# A A TAKLA ENGINEERING, PLLC

## FIELD REPORT

Date: 4/30/19  
Project: 4926 McDougald RD  
Location: Lillington, NC  
Company: Value Build  
Care of: Paul McNeill

Sheet #:  
ElevB-Pg5

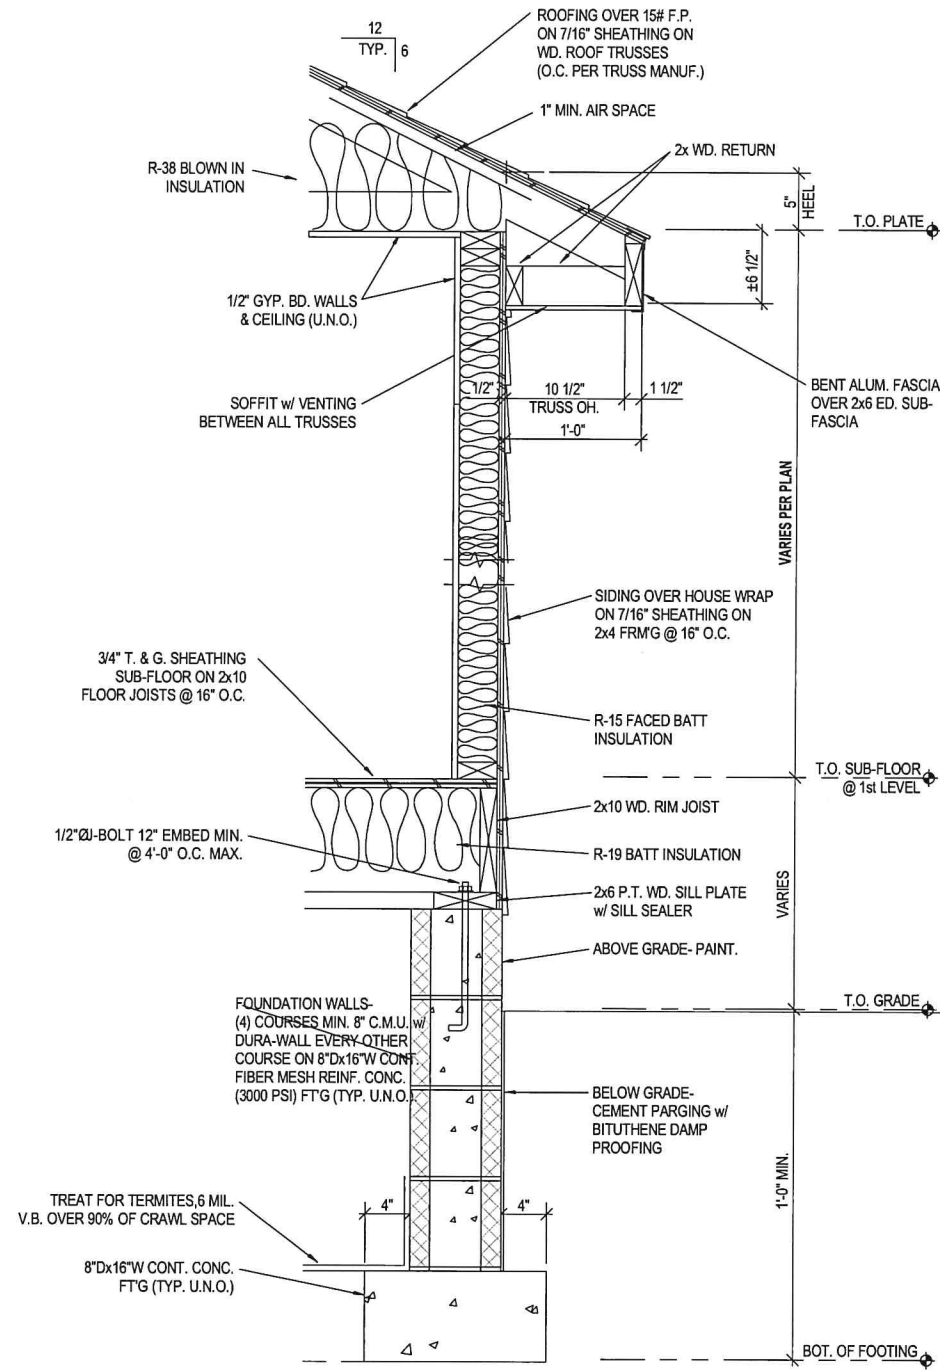
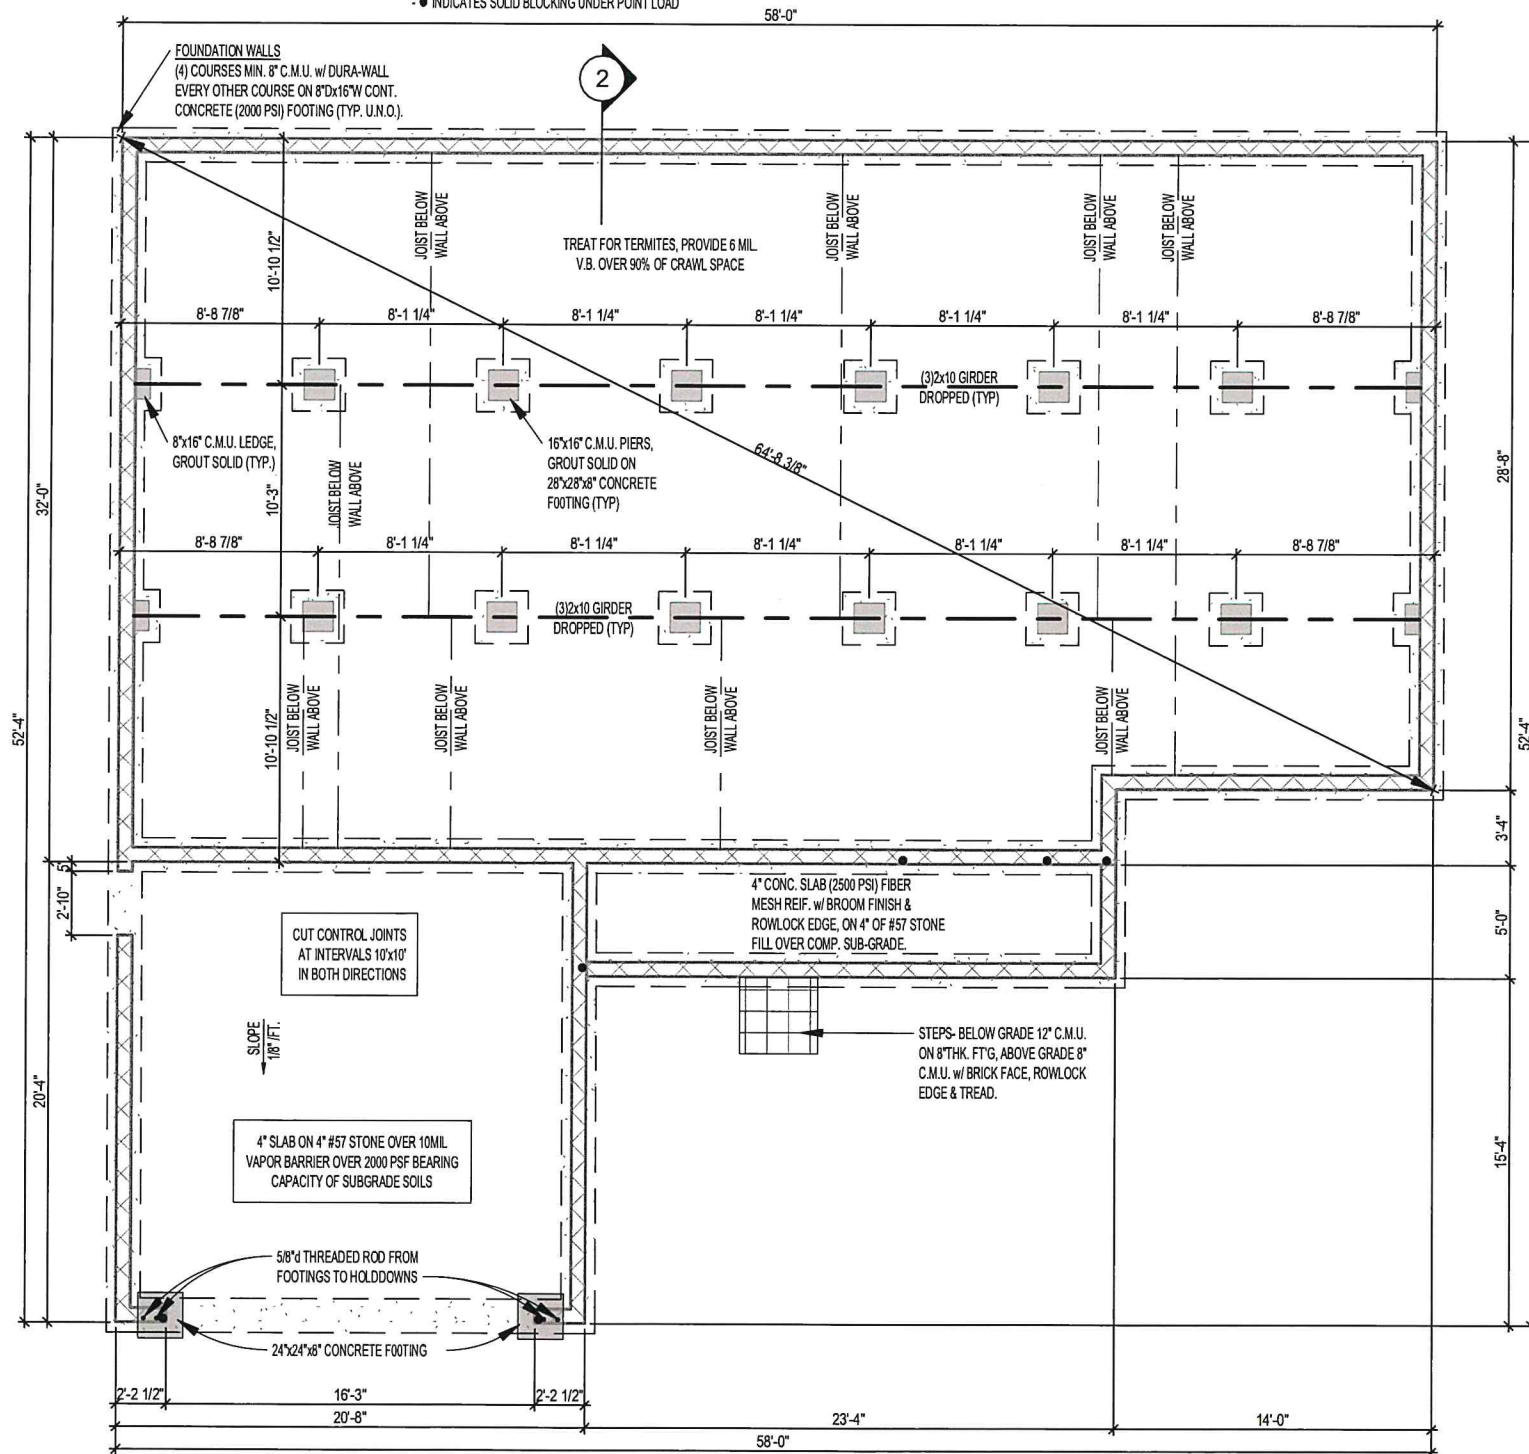
(A) Garage's Door Footing (was missing) was observed and found adequate per plan, meet code w/ 2000 psf bearing capacity

o.k TO pour
